## APPENDIX 2

### Agency Correspondence

**Re: SSD-10432 - Response to Council Submission re Traffic (Your Ref xxx )**

TIA Addendum Report – Prepared by GHD

Client	AUSTRALIAN RESOURCE DEVELOPMENT GROUP
Project	ARDG / ERS / BORAL - ITALIA ROAD ACCESS ARRANGEMENTS
Title	STRATEGIC CONCEPT DESIGN ALTERNATE OPTION 03
Original Size	A3
Drawing No:	22-19467-SK110
Rev:	A

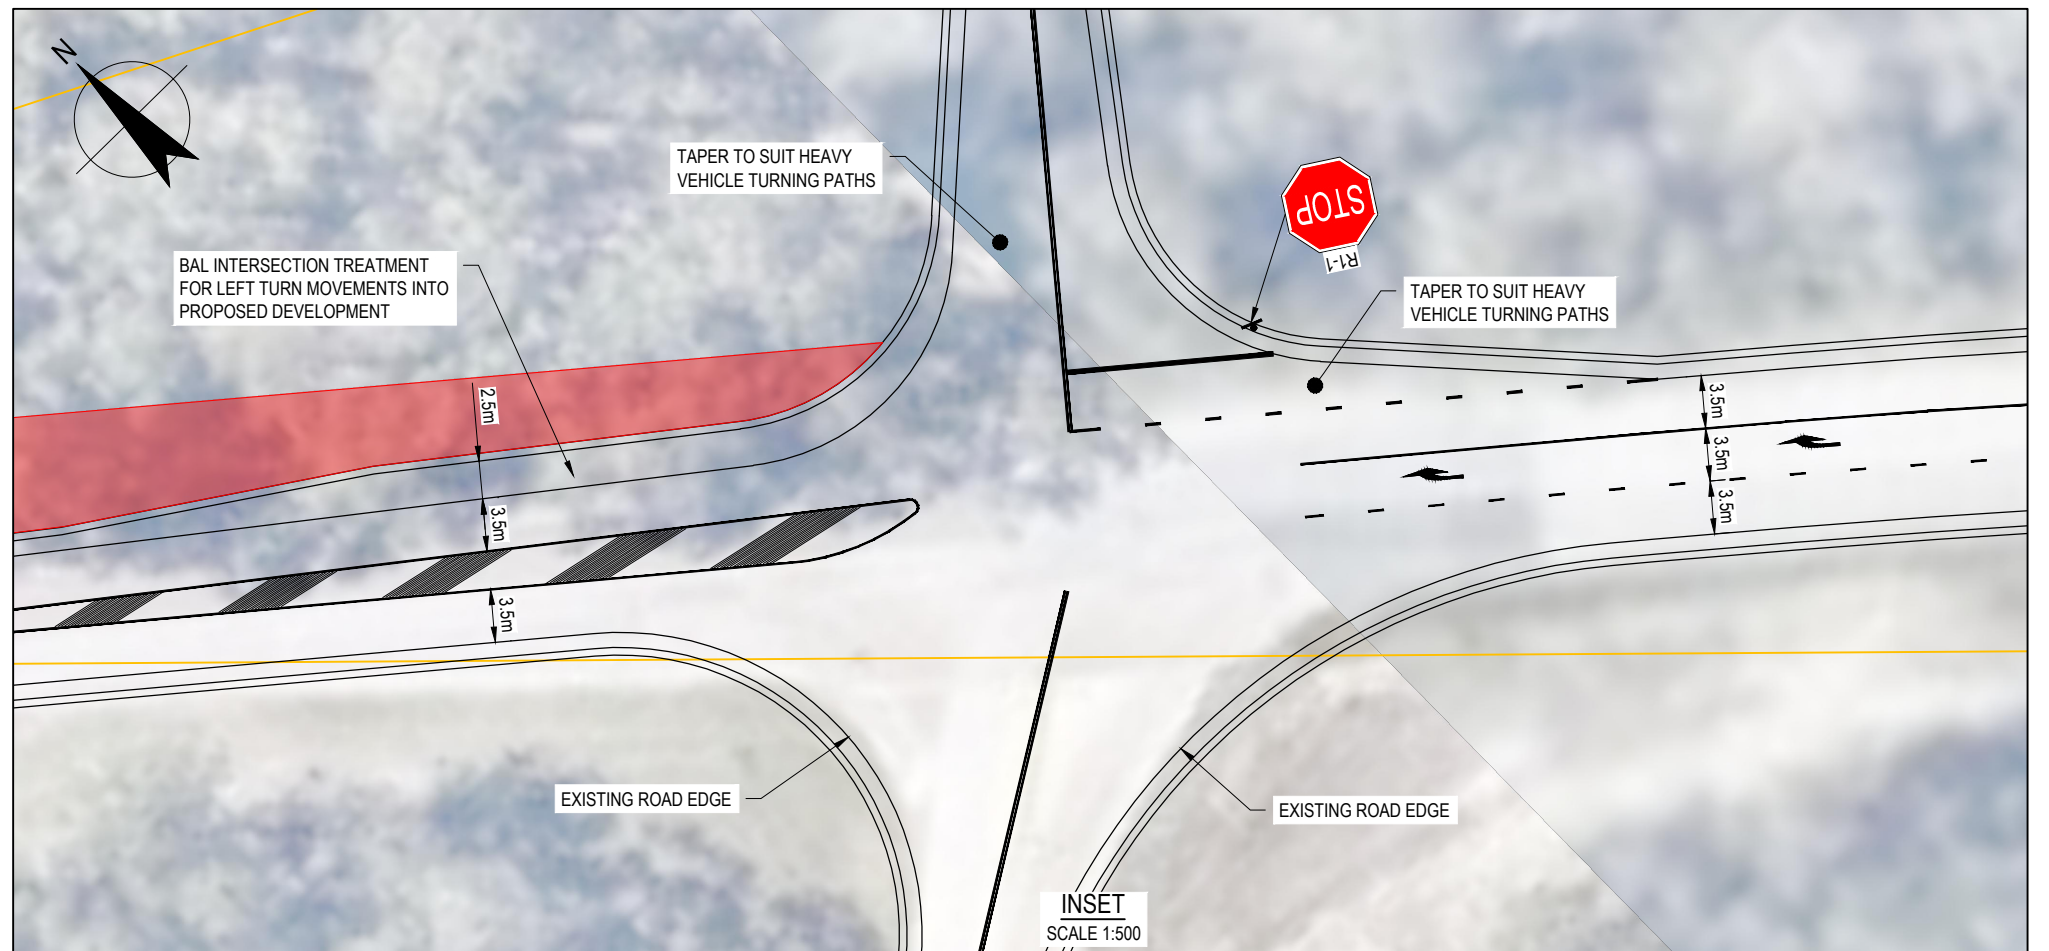
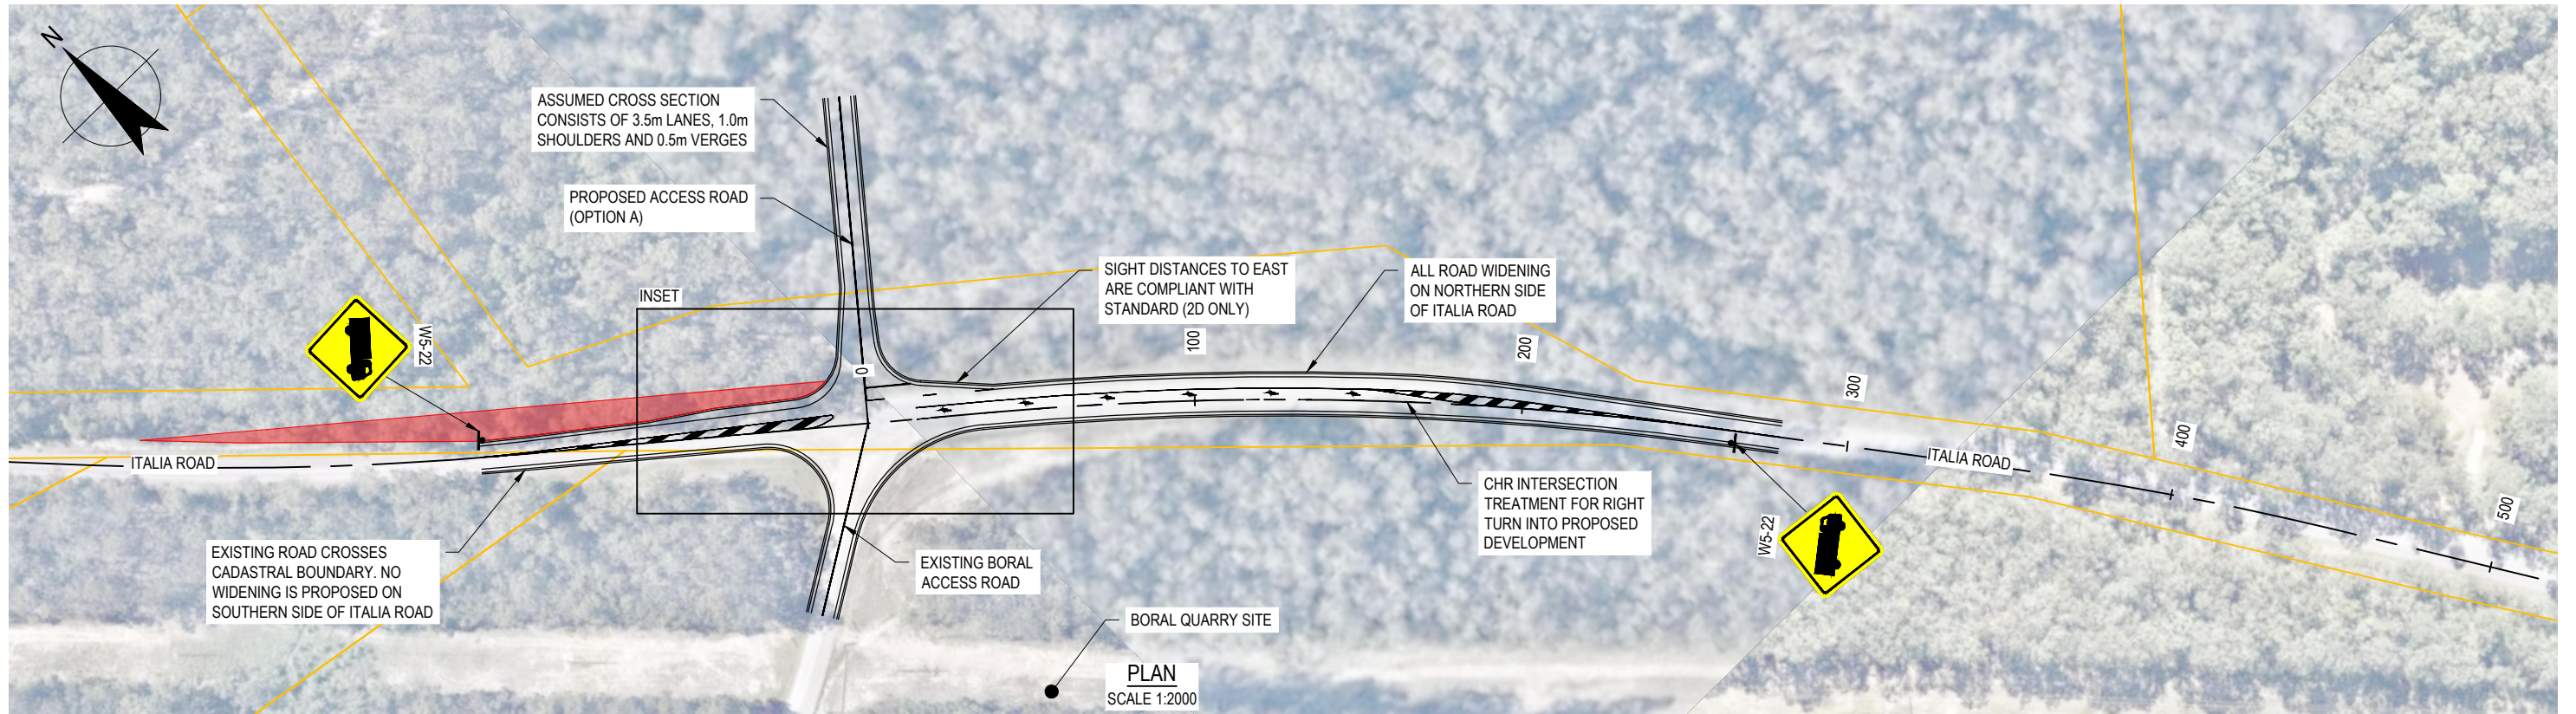
Item	Comment	ARDG Response
1	An enforceable undertaking will be required to ensure that all heavy vehicles use the left-in/left-out of Italia Road. The Transport Impact Assessment has not identified how physically this can be achieved.	<p>ARDG have already committed to the following management measure (refer to Appendix 3 of the EIS):</p> <p><i>No quarry product will be transported from the site until the Italia Road-Pacific Highway intersection works (the subject of a separate development application process by Boral) are completed to the satisfaction of Port Stephens Council/TfNSW. To prevent conflicts on the road network, heavy vehicles would only be permitted to turn left out of Italia Road onto the Pacific Highway.</i></p> <p>ARDG does not oppose conditioning of the development consent to reflect this management measure and it is anticipated that the means of implementing and monitoring compliance with this condition would be reflected in a Traffic Management Plan. Such a condition would be enforceable under the EP&amp;A Act through either civil or criminal enforcement procedures.</p> <p>An alternative or additional measure can include a regulatory sign posting regime at and in advance of the proposed intersection upgrade (subject to a separate application) to prohibit quarry trucks turning right from Italia Road onto the highway. The specifics would be subject to detail design and Section 138 approval under the Roads Act. ARDG would not be opposed to such a measure being implemented and note that this would be consistent with the existing proposed management measure reproduced above.</p> <p>As per the Australian Road Rules Regulations, this is enforceable with a maximum penalty of 20 units.</p> <p>It is noted that ARDG cannot make undertakings associated with heavy vehicle movements associated with other quarries or heavy vehicle movements servicing other residences and businesses on Italia Road.</p>

Item	Comment	ARDG Response
2.4.3	Heavy Vehicle north-south split, banning of all right turns into Italia Road.	As per item 2.4.1 and 2.4.2
3	The proposed channelisation treatment at the quarry access road off Italia Road is considered satisfactory and could cater for the right turning traffic for the life of the quarry. However, the existing Basic Left Turn (BAL) treatment for the Boral Quarry Access has been removed from the proposed design and should be included in the design.	The Boral access has not been removed. It is only proposed to configure the intersection on the northern side of Italia Road to suit the proposal, no works are proposed as part of the Project that would impact the Boral access. Potential access issues associated with Boral access are considered in the attached TIA Addendum.
4	The TIA or EIS should include a discussion on alternate design options that were previously proposed for the intersection, including the grade separated interchange and the justification for the selected intersection design.	As outlined in the EIS and TIA the proposed intersection works do not form part of the Project and approval is being pursued under a separate assessment process. As noted above and in the EIS, significant optioneering and engagement was conducted with TfNSW since 2019. Consultation with Council regarding traffic issues, including the Italia Road / Pacific Highway intersection, has occurred on numerous occasions, including meetings in 2019, 2020 and 2022 (x2 meetings) TfNSW subsequently advised they would undertake strategic network planning for a Pacific Highway corridor extending from Raymond Terrace to north of the Bucketts Way. This broader strategic network planning is beyond the scope of the Project. Refer to TfNSW's correspondence for in principle support for the intersection treatment, submitted with the separate development application for the intersection works (currently under assessment by PSC).
